Drainage Report Final_V1 REDLINES.pdf Markup Summary

Preliminary and Final DRAINAGE PLAN AND REPORT

ROCKY TOP MOTEL AND CAMPGROUND

County File No.: PPR2140

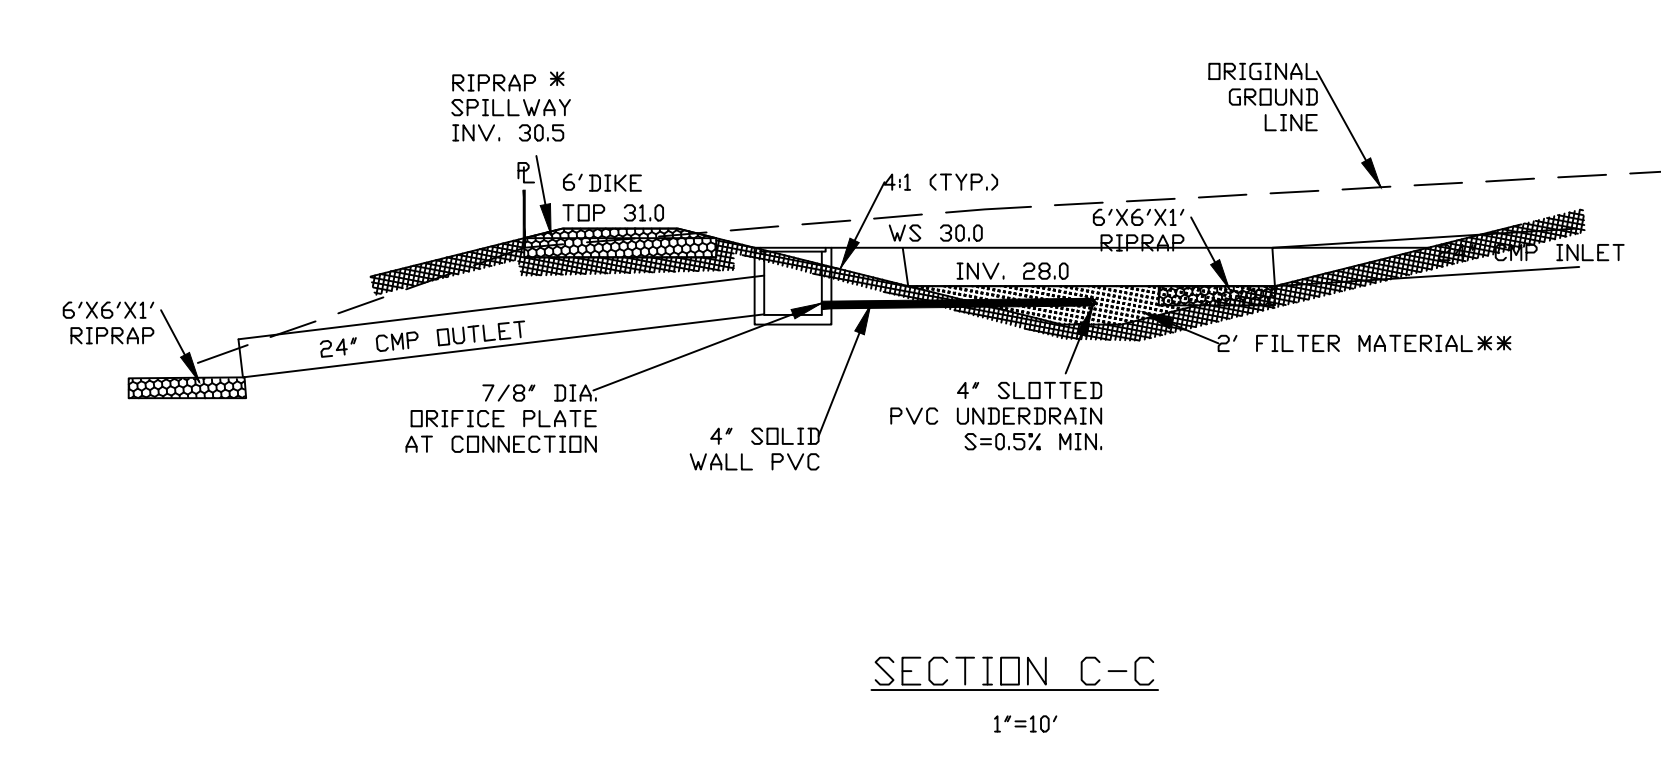
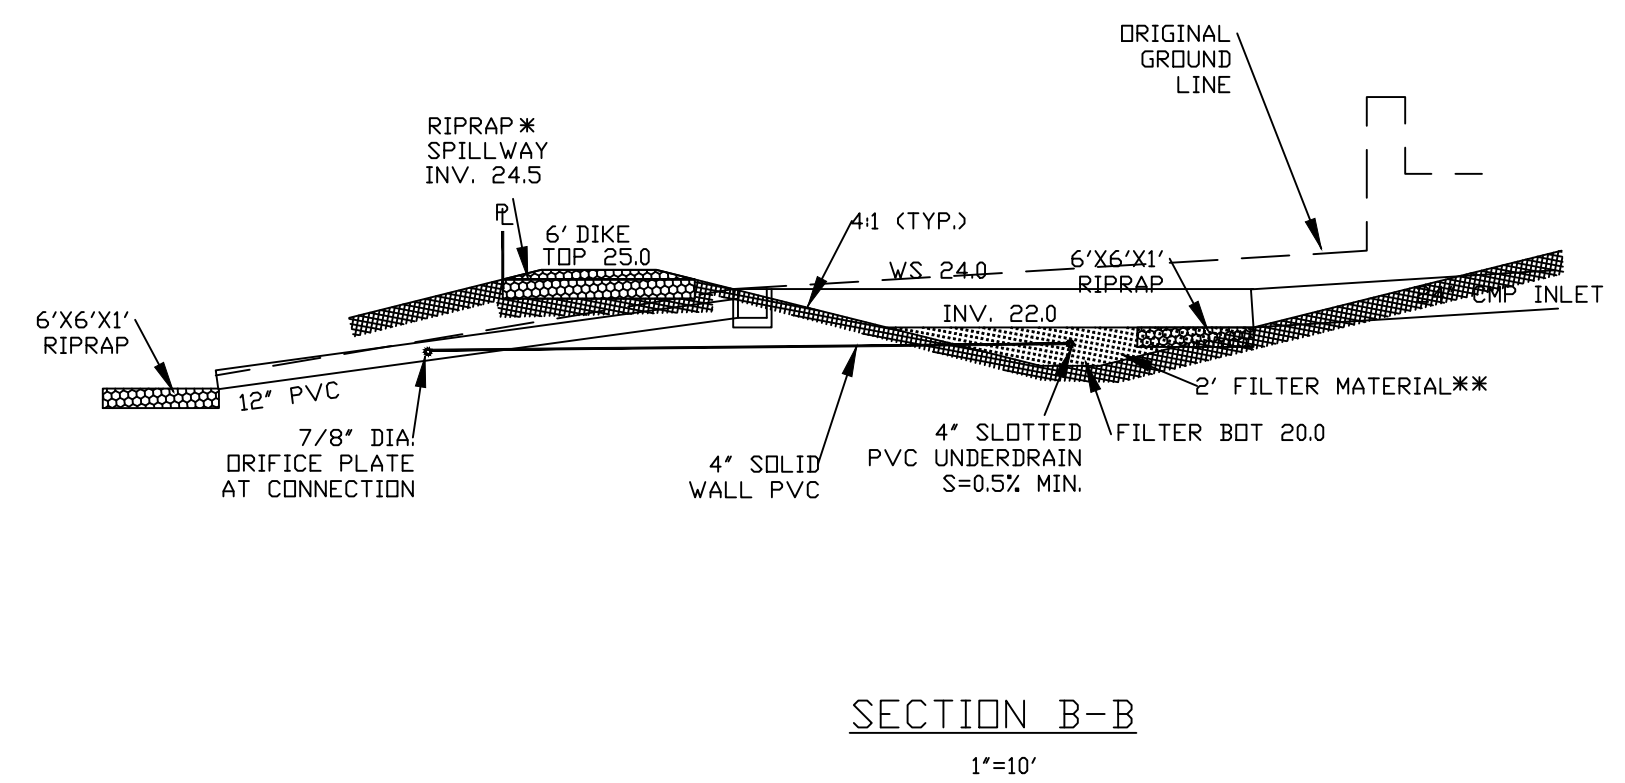
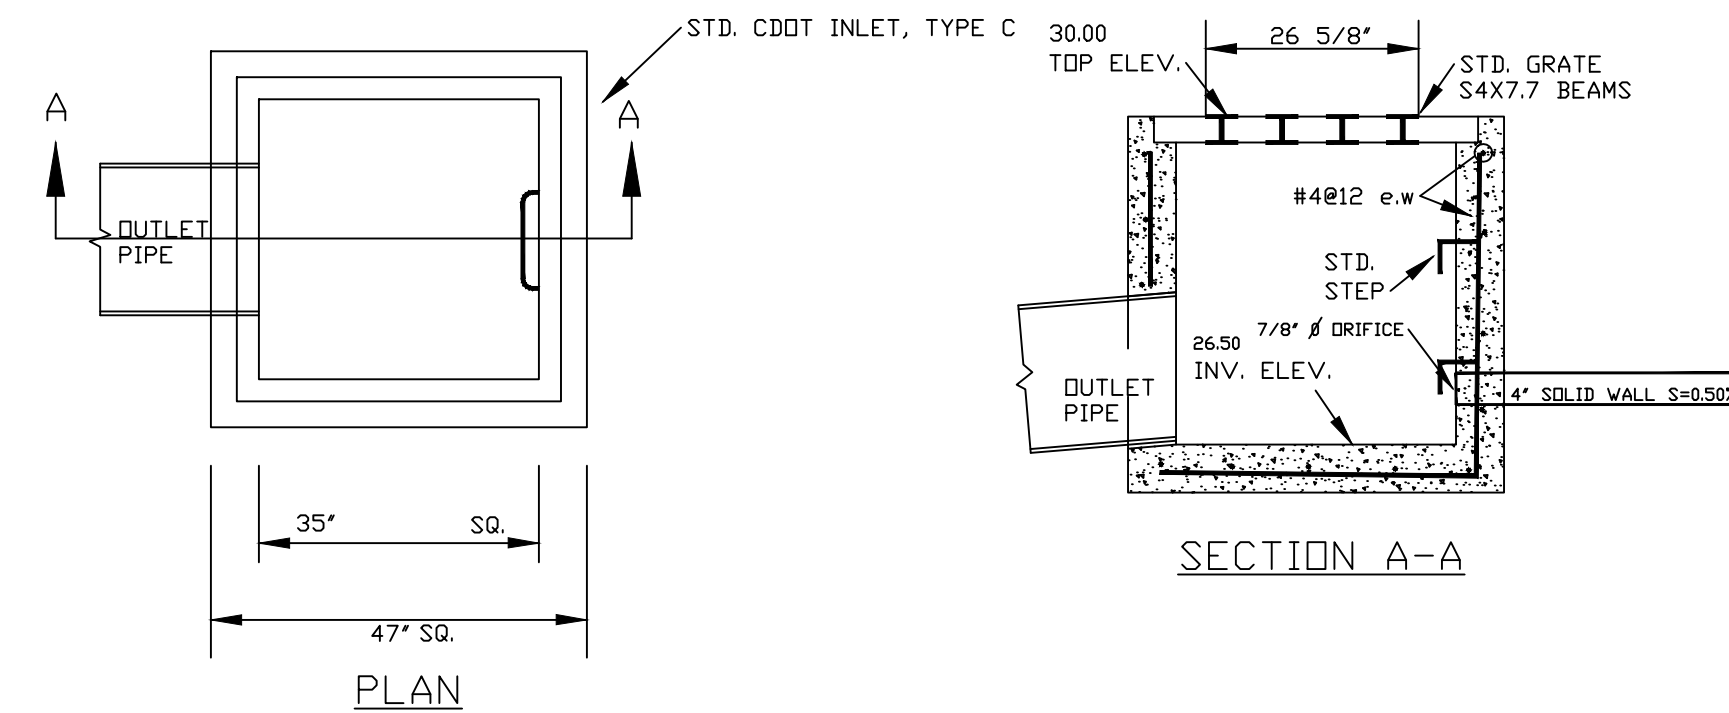
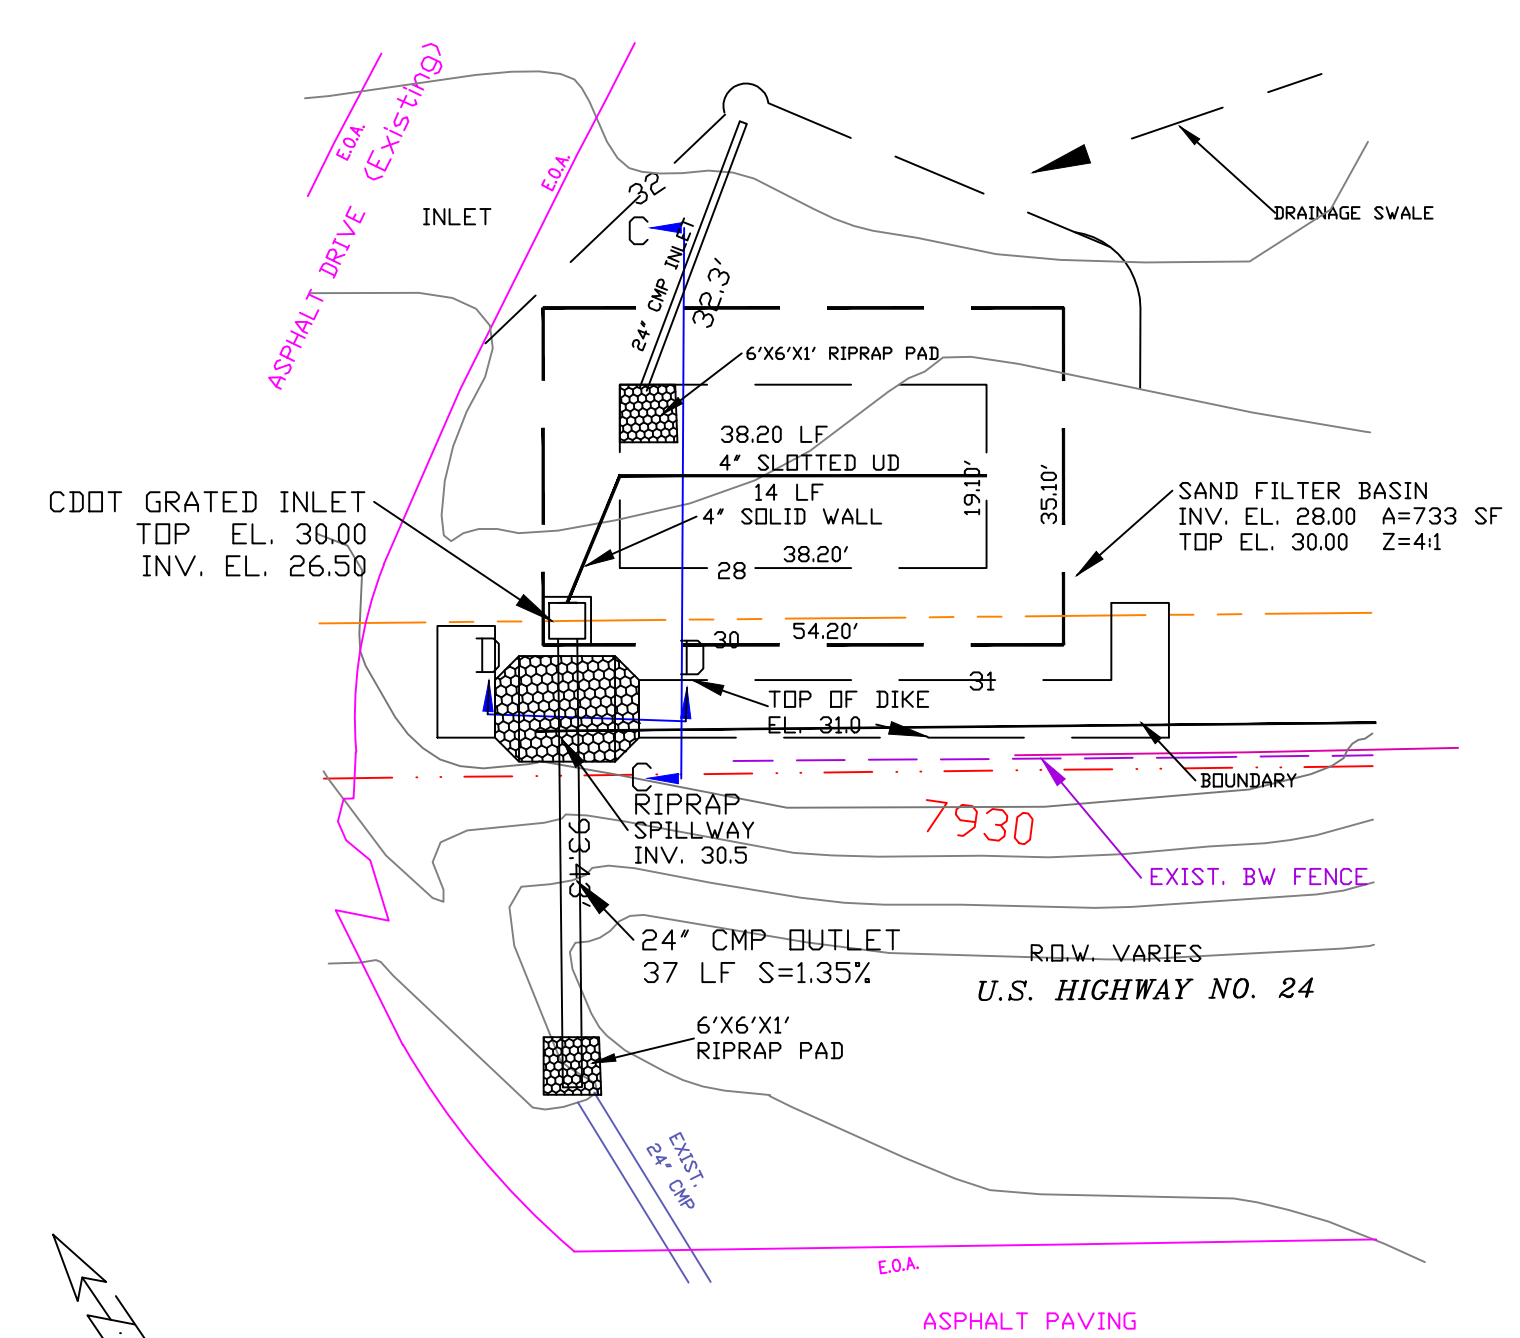
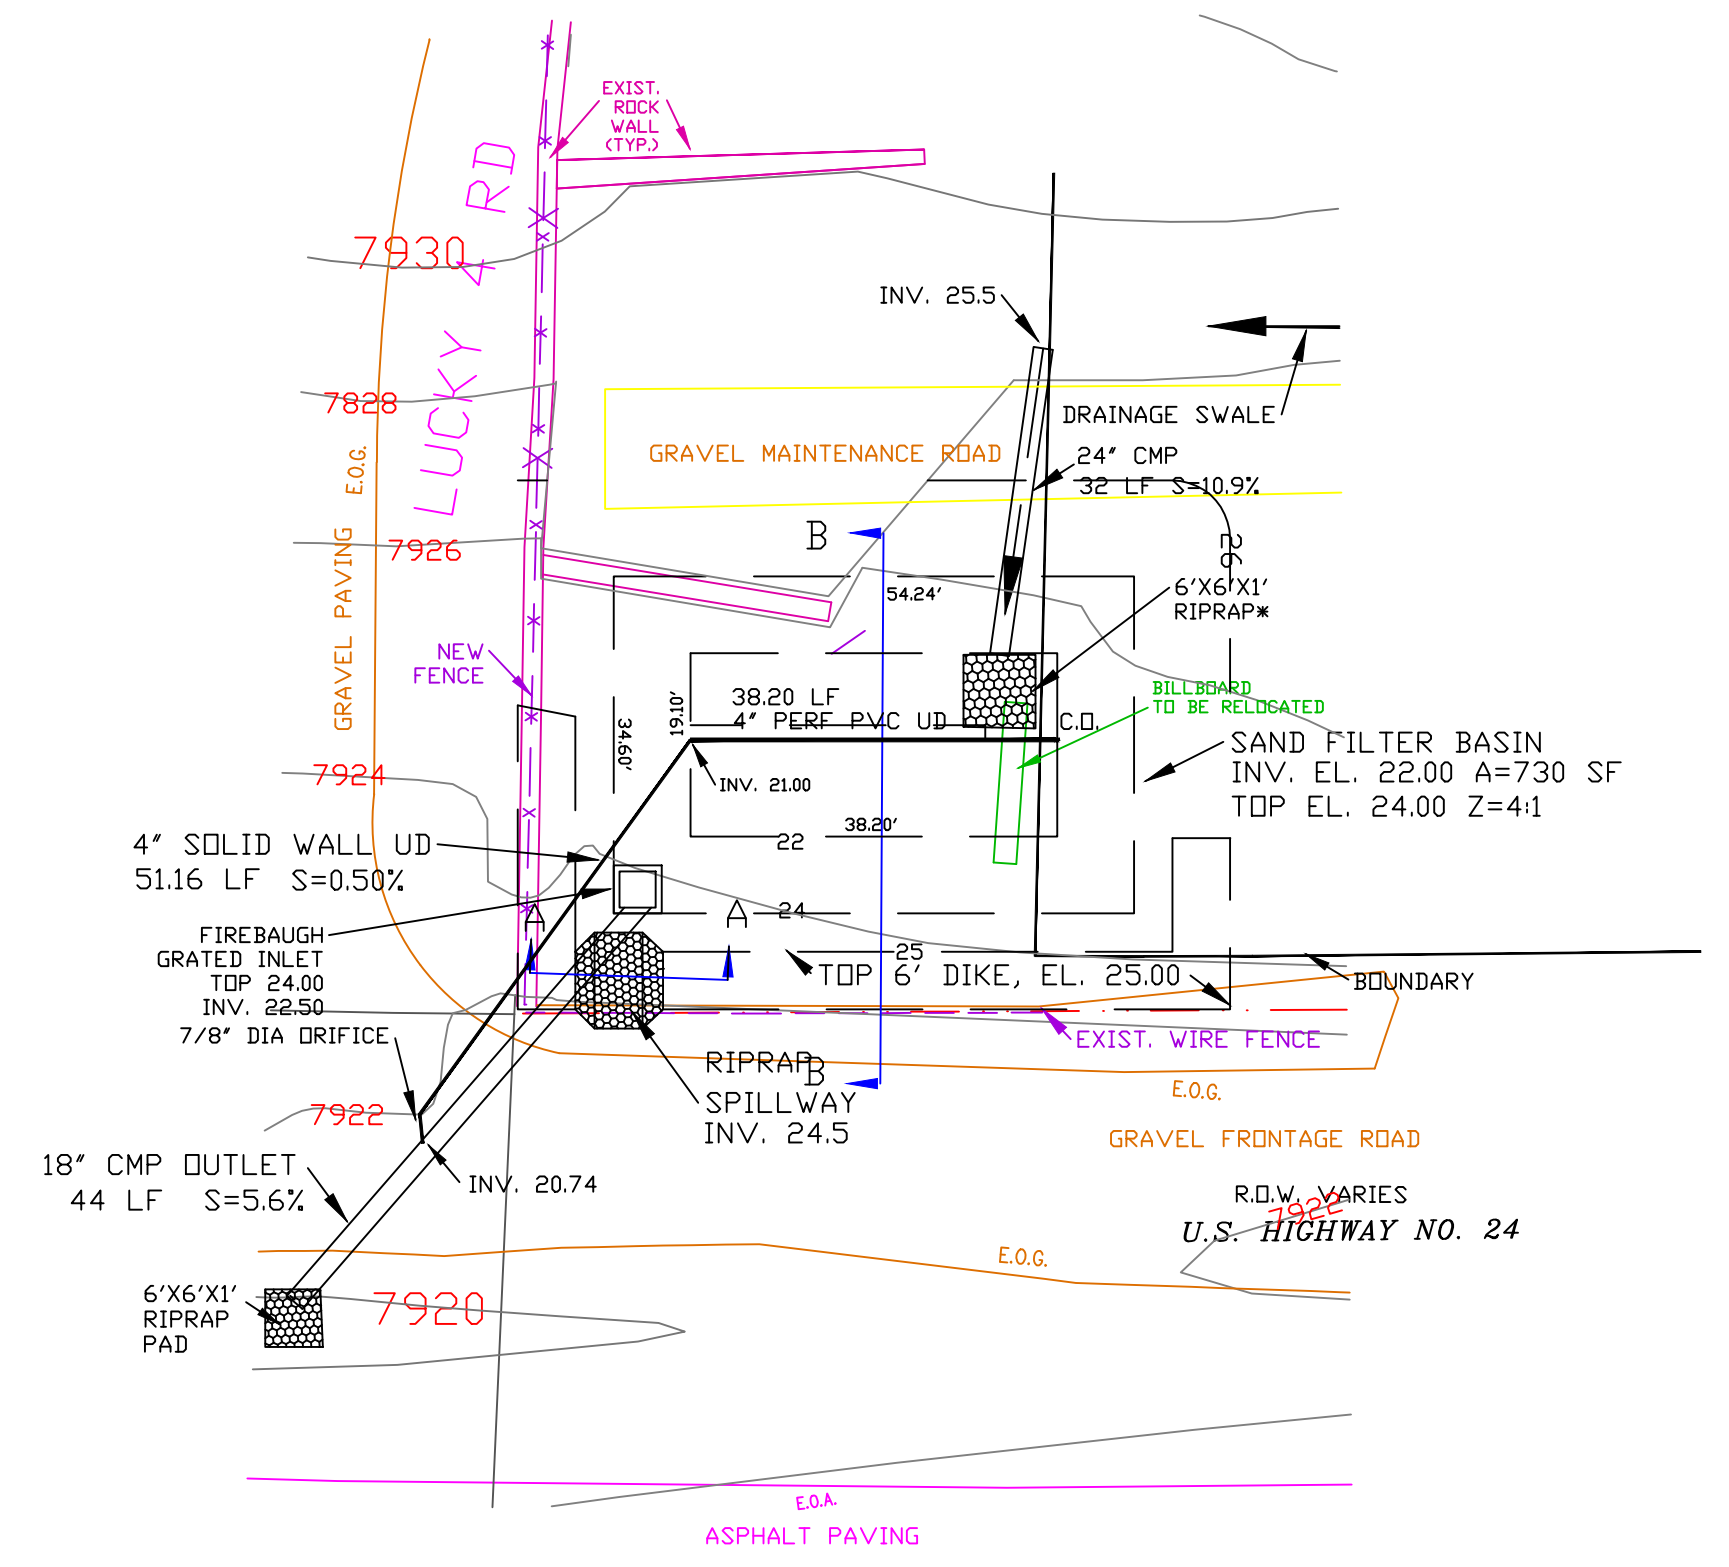
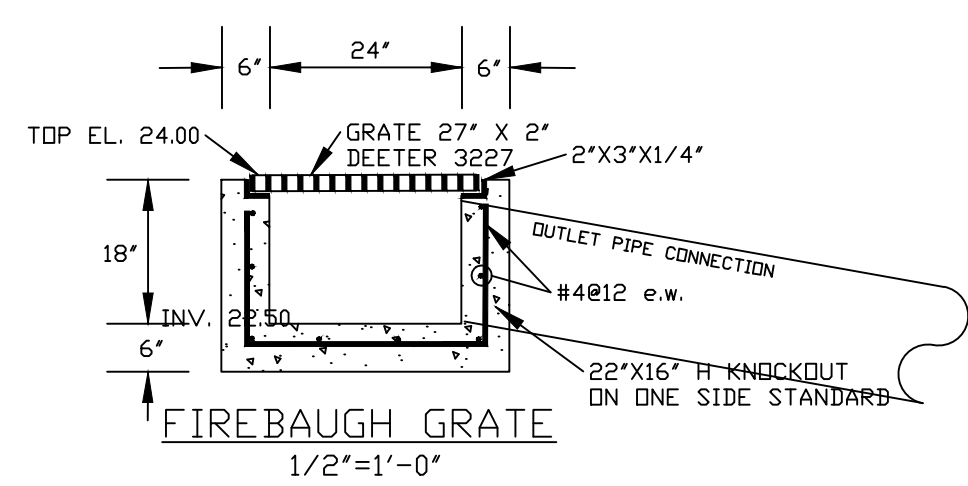
Please label what is existing and what is proposed. Also provide analysis of the CMP's

Per these existing contours and flow arrow it appears that the flow will not be directed to the sand filter basin. Please adjust the contours as necessary and/or relocate the basin.

Identify the outfall/spillway of the sand filter basin(SFB). How will be outfall of each of these SFB be conveyed to the downstream facilities? Please discuss in your narrative

Provide LxWxH dimensions of riprap apron.
 Also specify the type of riprap.

Provide sections/alignments of pipes to show depth, length, finished grade, etc.

Provide LxWxH dimensions of riprap apron.

Also specify the type of riprap.
